Office of Environment & Heritage

Your reference: SSD 5093
Our reference: DOC14/156230
Contact: Rachel Hannan
02 8837 6088

I refer to your correspondence to the Office of Environment and Heritage dated 6 August 2014 advising of the public exhibition of the SSD application for the M2 site, North Ryde Station Urban Activation Precinct.

OEH has reviewed the Environmental Impact Statement (EIS) and provides the following comments.

Figure 12: Porters Creek riparian corridor

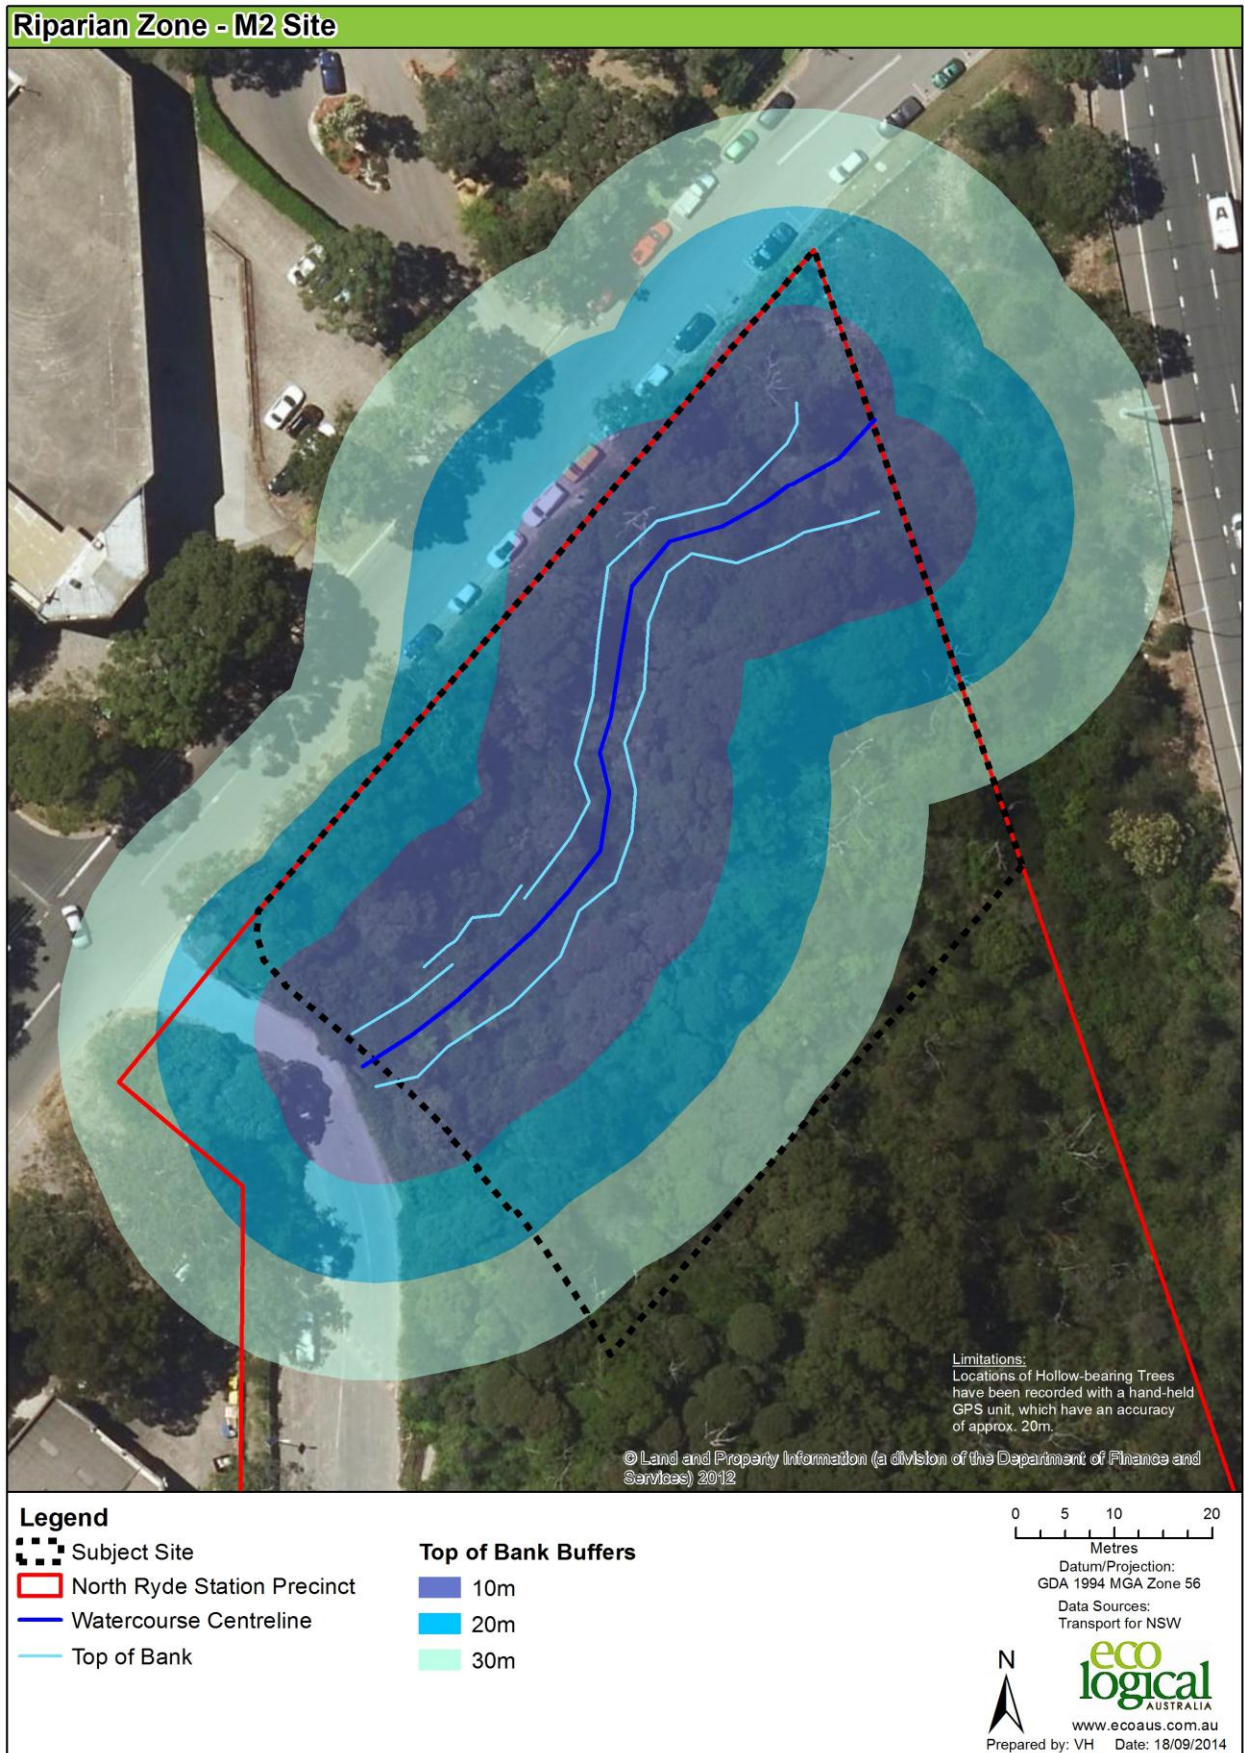
The Stormwater Management Plan (Appendix H) proposes modifications to the culvert under Spine Road to accommodate stormwater flows to Porters Creek, in the proposed bushland reserve. It is unclear whether this section of Porters Creek is also to form a stormwater detention function. The physical structures for stormwater drainage, particularly the extent of area of scour protection, are inconsistent with the designs and proposals in the Urban Design and Landscape Plans (Appendix E), Ecological Impact Assessment (Appendix J) and Vegetation Management Plan (Appendix K).

The impacts of the proposed stormwater drainage management within the bushland reserve (physical construction and potential impacts to creek stability and the vegetation community) have not been identified or assessed.
